# Charlotte Department of Transportation

## Memorandum

**Subject:** Rezoning Petition 08-064: Located on the west side of Frazier Avenue  
between West 5th Street and Martin Street

NOTE:  
THE PETITIONER RESERVES THE RIGHT TO SEEK A VARIANCE TO ALLOW A SWIMMING POOL ON PARCEL ID#07819312.

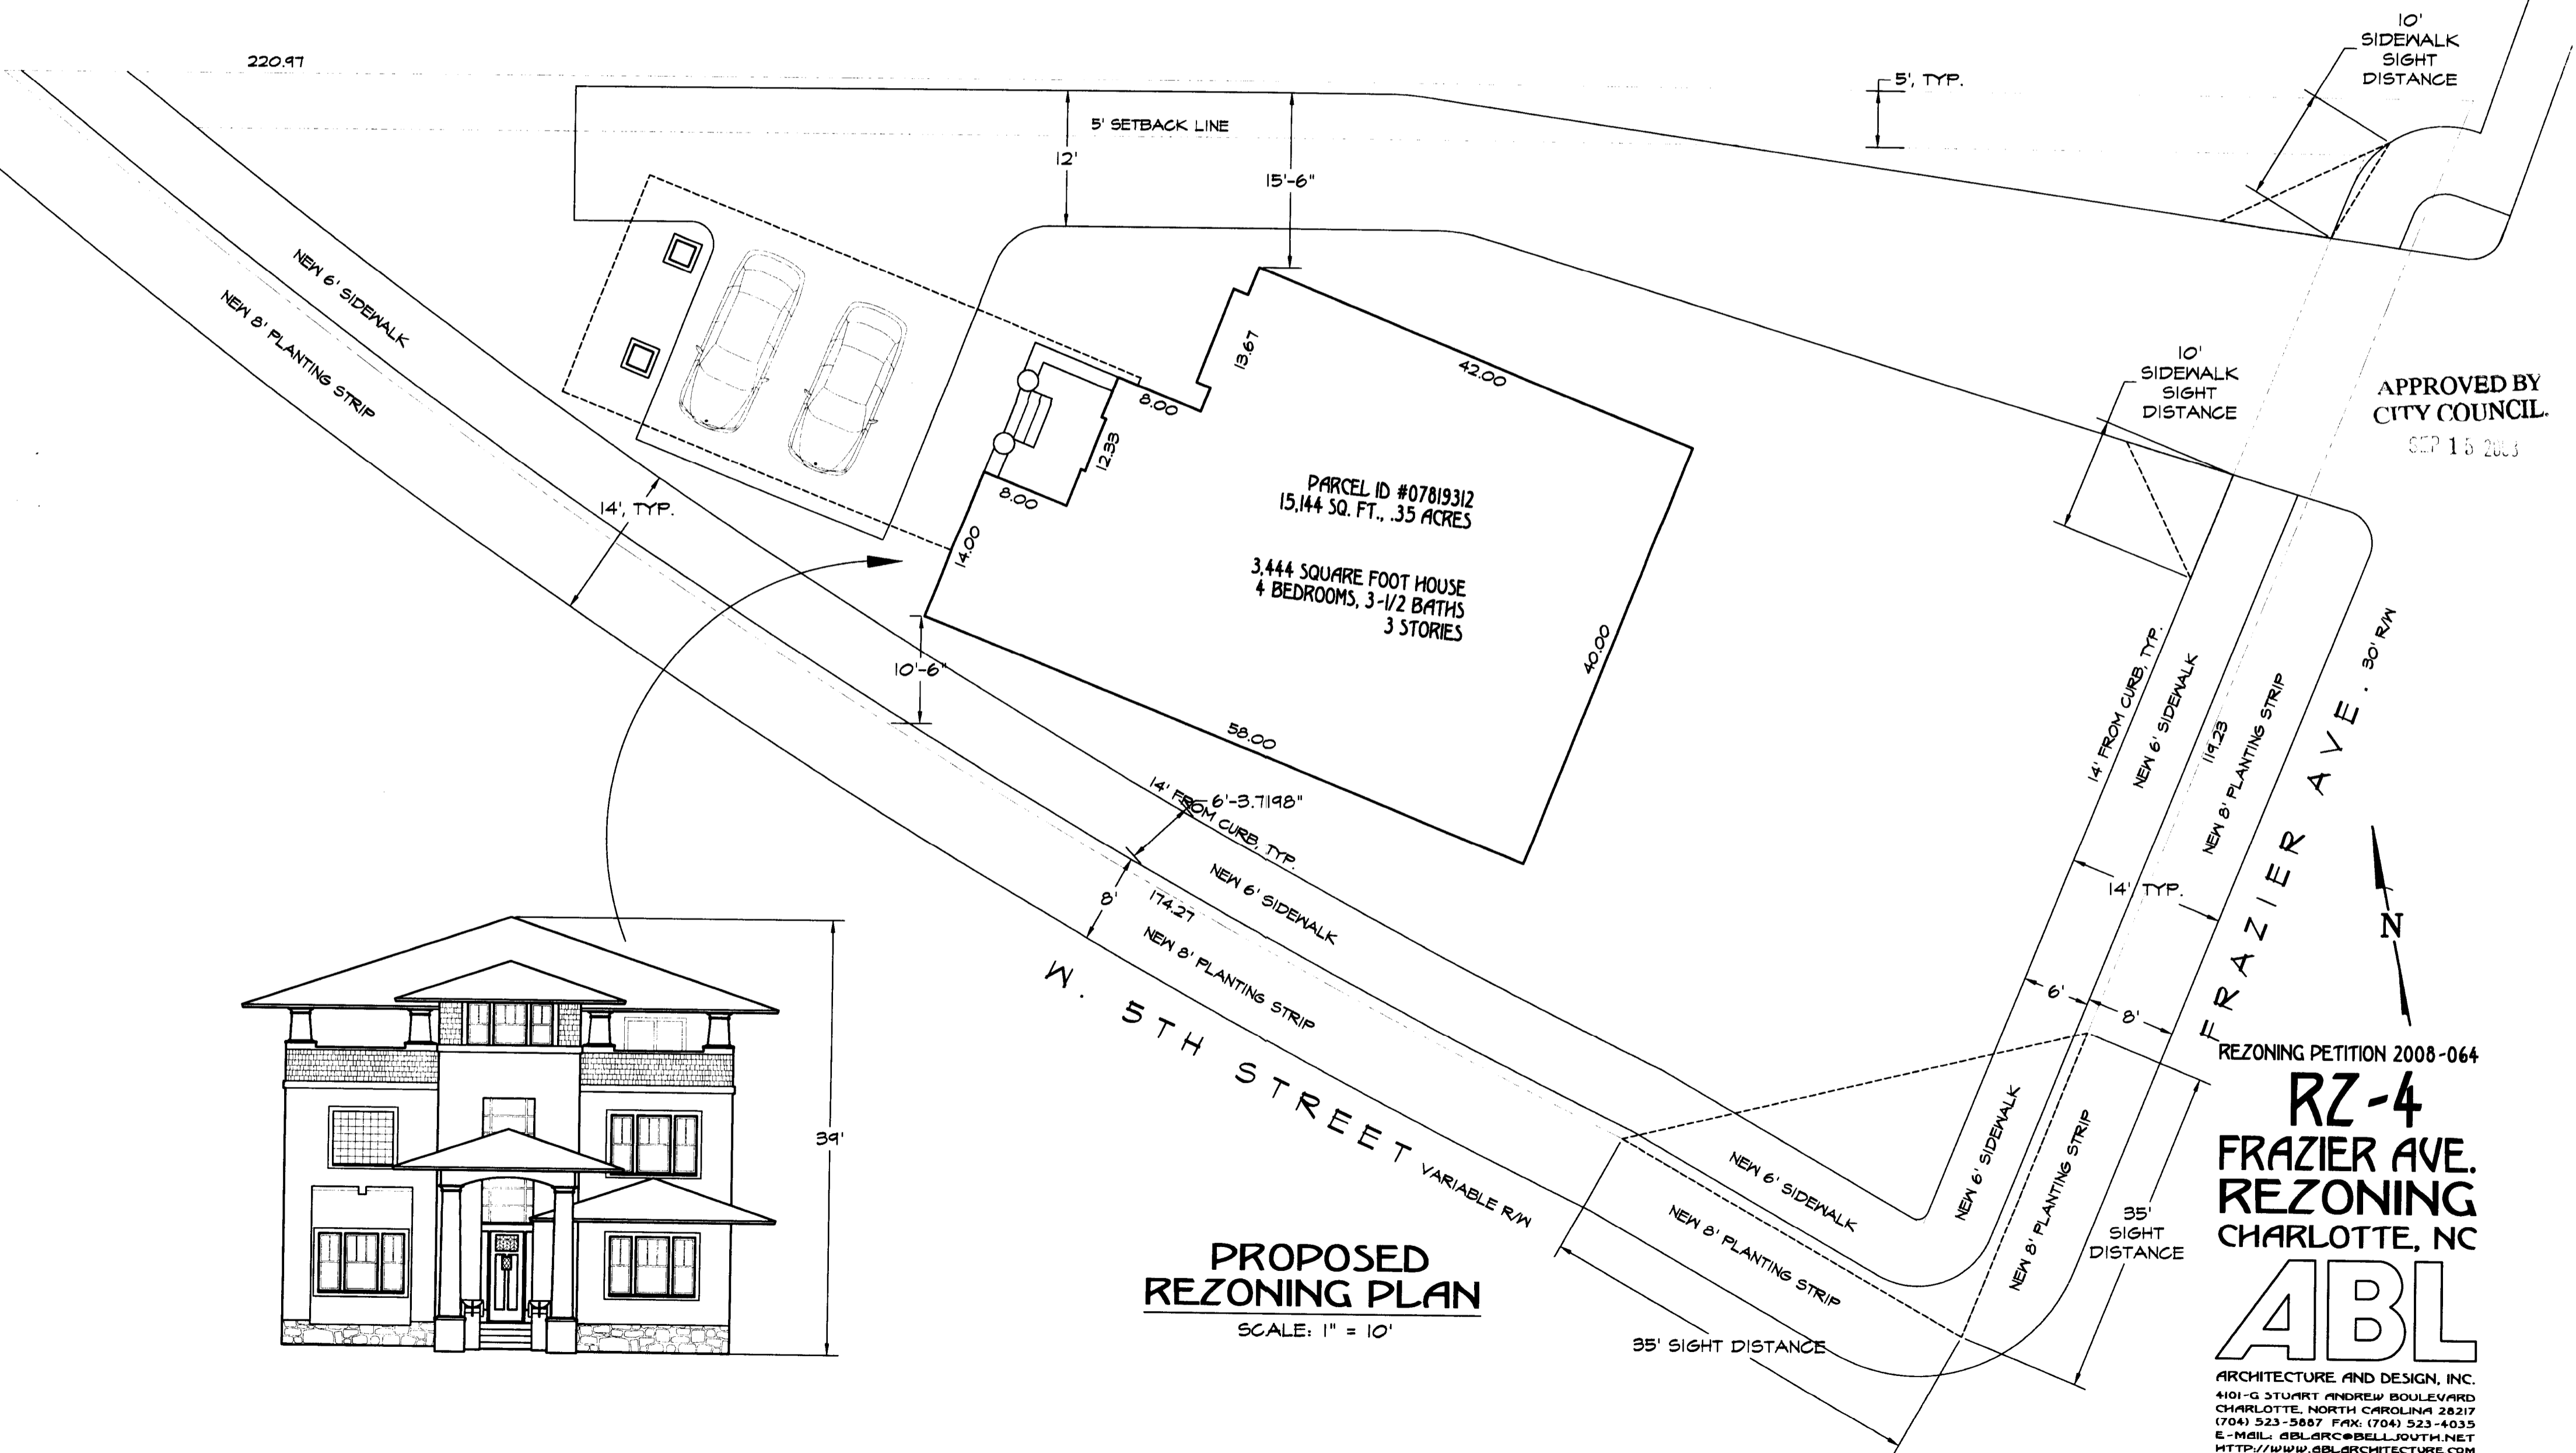
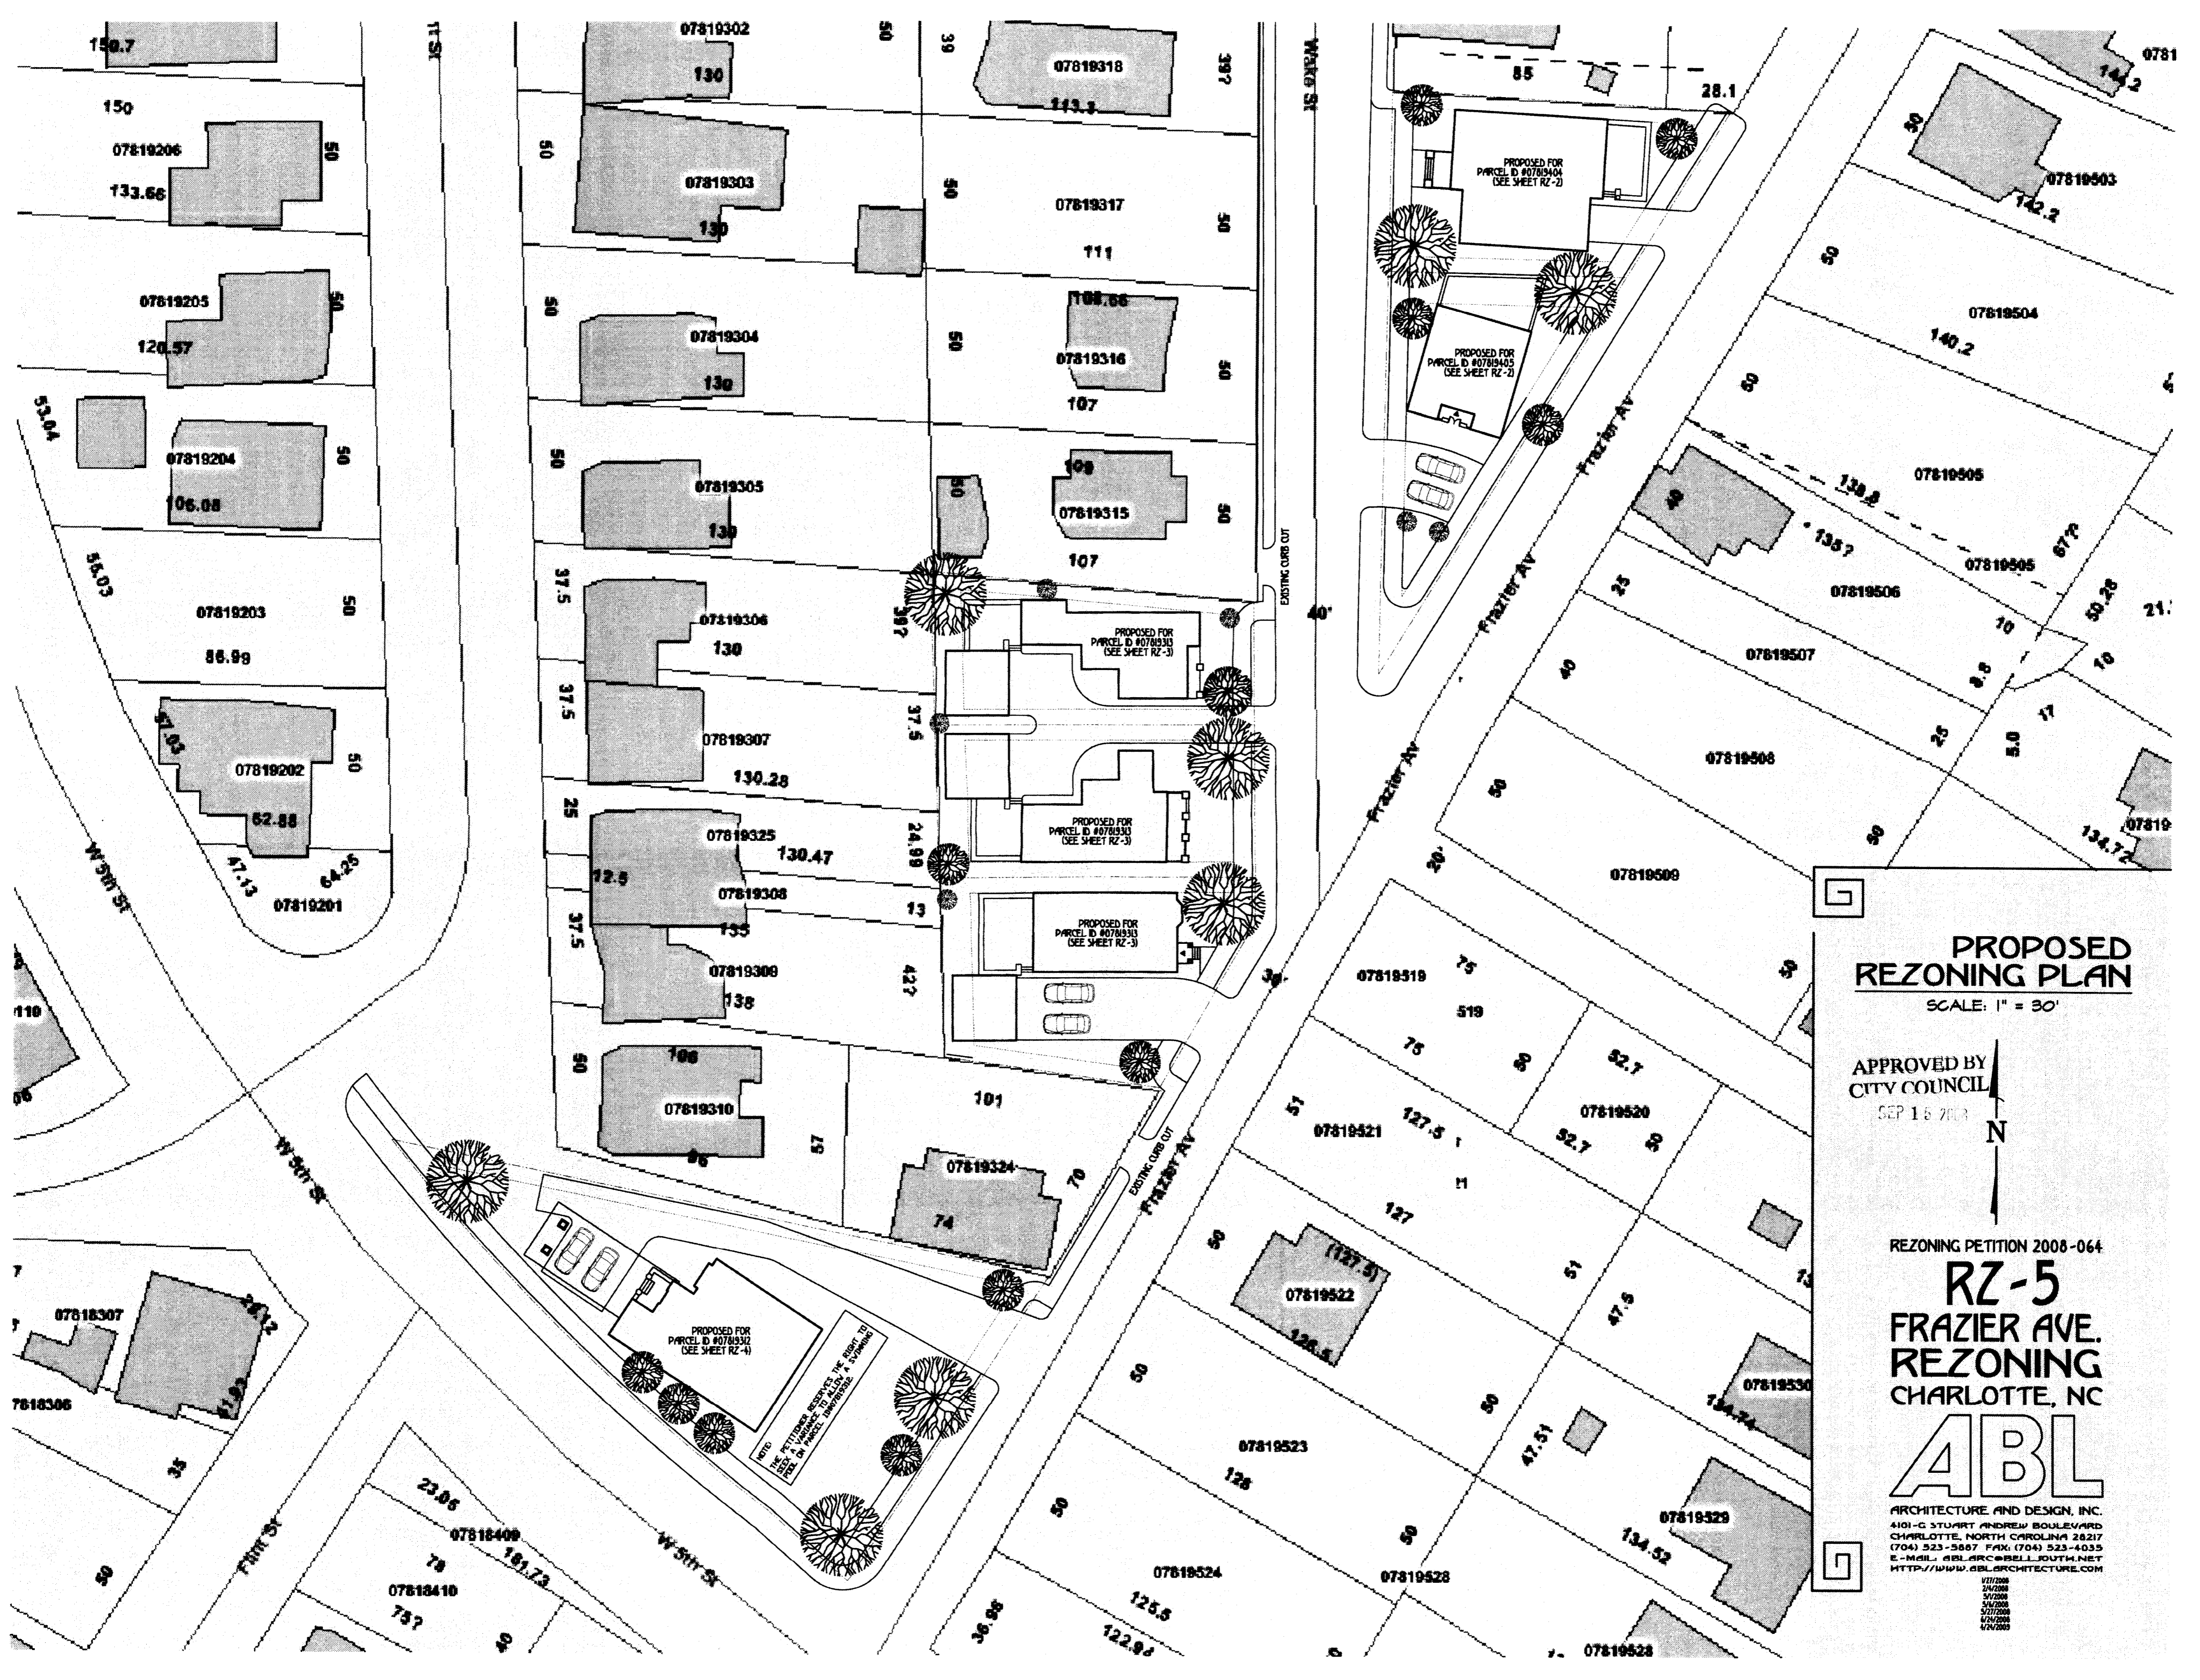
1. The existing sidewalks that are located at the back-of-curb along Wake Street and Frazier Avenue need to be replaced with 4' planting strips and 5' sidewalks to be in conformance with the existing character of the surrounding neighborhood, except where existing stone walls need to be preserved.
2. Normally, the existing sidewalk at the back-of-curb along West Fifth Street would warrant a request for replacement by an 8' planting strip and 6' sidewalk. However, there appears to be challenges in topography. The petitioner is requested to contact CDOT's Pedestrian

Program Manager (Vivian Coleman at 704.353.0481) to discuss alternative designs that still enhance the pedestrian realm while minimizing grading issues.

3. At least a 20-foot offset needs to exist between the back-of-sidewalk and the front of each garage. The 20-foot space is necessary to provide enough storage for a vehicle without blocking the public sidewalk.

4. The proposed pull-through driveway located on tax parcel #07819405 at the corner Frazier Avenue and Wake Street needs to be removed from the plans. CDOT can only support one driveway for this residential unit.

5. The City's *Driveway Regulations* require driveways to be perpendicular (90°) to the street and set back. At least two of the driveways are at angles between 60-70° and cannot be approved.

6. Stone walls are shown along the street frontages of several of the units. The installation of fences and walls along or adjacent to the street right-of-way, require a permit issued by the CDOT. Walls will be restricted or prohibited within sight triangles at intersections and at driveway locations. Clear visibility (no obstructions) within these triangles must be maintained in a vertical clearance of 30-72" as measured from the ground surface. These items cannot be located within the right-of-way. Please provide a detail of the stone walls on a revised site plan.

7. A 35-foot by 35-foot sight distance triangle needs to be provided at the intersections of Frazer Avenue/Wake Street and Frazer Avenue/ West 5<sup>th</sup> Street. Two 10'x10' pedestrian sight triangles are required for each driveway connection to meet minimum requirements. One leg of the triangle is measured along the driveway, and the other leg is measured along the back of the sidewalk or right-of-way, which ever is the greater distance from the face-of-curb. All proposed structures, trees, berms, walls, fences, and/or identification signs must not interfere with the sight triangles at the driveway connection. Such items need to be identified on the site plan.

- Dimension width of the existing and proposed driveways.
- Indicate the locations and widths of all adjacent and opposing driveways.
- Indicate typical vehicle parking lengths in the proposed driveways so that they do not conflict with the sidewalk.
